# Gatwick Airport Northern Runway Project

Response to the Examining Authority's Written Questions  
(ExQ2) – Ecology and Nature Conservation

Application Document Ref: 10.56.5

Airport Preliminary Tree Removal Plans
Appendix 8.10.1
Sheet 9 of 13

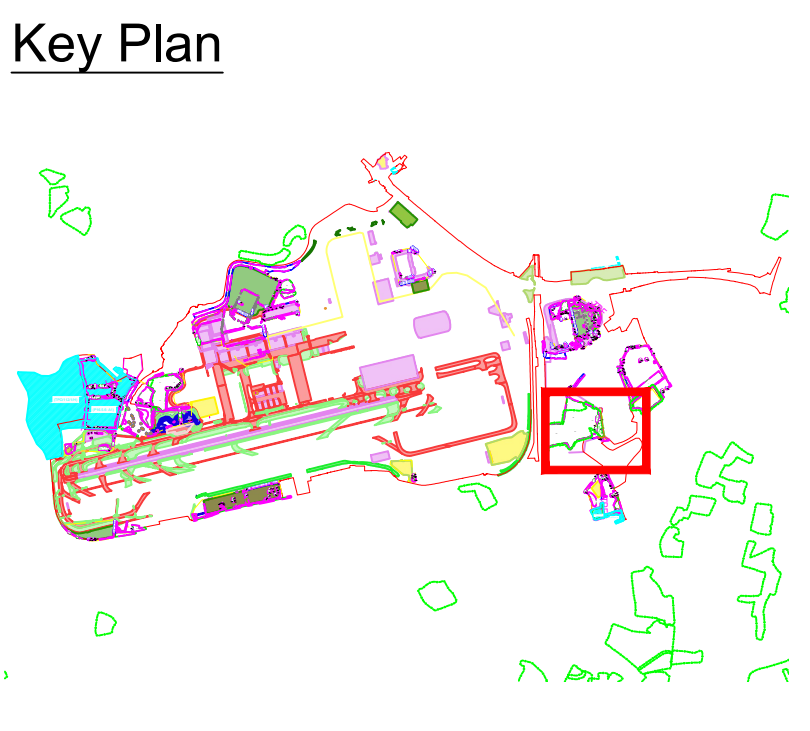
<p>These Project-wide Design Principles are applied to the Project as a whole and therefore a separate site-specific Design Principle to manage light spill from the proposed multi-storey car parking is not necessary.</p>
EN.2.4	West Sussex Joint Local Authorities	<p><b>Realistic worst-case tree removal</b></p> <p>In response to comments from the West Sussex Joint Local Authorities, the Applicant has reduced the extent of tree removal along the surface access corridor in the outline Arboricultural and Vegetation Method Statement (oAVMS) submitted at D6 [REP6-018].</p> <p>The West Sussex Joint Local Authorities are asked to comment on whether it is satisfied that the proposed tree removal represents a realistic worst-case? And, if not, identify where requirement for removal has not been demonstrated.</p>
		N/A – this question is not directed at the Applicant.
EN.2.5	Applicant	<p><b>Horleyland Woods - Alignment of surface water/ foul water works</b></p> <p>The ExA notes that the oAVMS [REP3-022] states the proposed surface water/ foul water works will be changed during detail design to be outside of the 15m buffer zone for Horleyland Woods.</p> <p>The Applicant is asked if Appendix B of the oAVMS [REP3-026] will be updated and submitted into the Examination showing the indicative route of the works outside of the 15m buffer zone?</p>

<p>The <b>Code of Construction Practice Annex 6 – Outline Arboricultural and Vegetation Method Statement</b> [<a href="#">REP6-018</a>, <a href="#">REP6-020</a>, <a href="#">REP6-022</a>, <a href="#">REP6-024</a>, <a href="#">REP6-026</a>, <a href="#">REP6-028</a>] has been amended and submitted into the Examination at Deadline 7. The text within Section 3.3 has been amended as follows <i>‘Horleyland Wood is adjacent to the proposed surface water/foul water works. The indicative alignment of the underground services</i></p>

<p><i>is located outside of the 15m ASNW buffer zone (See Appendix B). The Airport Preliminary Tree Removal and Protection Plans, sheet 9 of 13, Diagram. 758 will be amended.</i></p> <p>Project Change 4 relates to the On-Airport Wastewater Treatment Works ('On-airport WWTW') and which has been accepted by the ExA into the Examination. In the event that the On-airport WWTW forms part of the final Project (as it is an 'alternative' solution for wastewater treatment as explained in the <b>Second Change Application Report</b> [<a href="#">REP6-072</a>]), the proposed pipeline on the eastern side of the Brighton-London mainline railway connecting to Crawley Sewage Treatment Works (and which is currently shown within the Horleyland Wood Ancient Woodland buffer zone) would not be required. The detail of Project Change 4, including any changes to the proposed wastewater pipelines in the event that the On-airport WWTW is delivered as part of the Project, is explained in paragraph 2.2.6 of the <b>Second Change Application Report</b> [<a href="#">REP6-072</a>].</p>
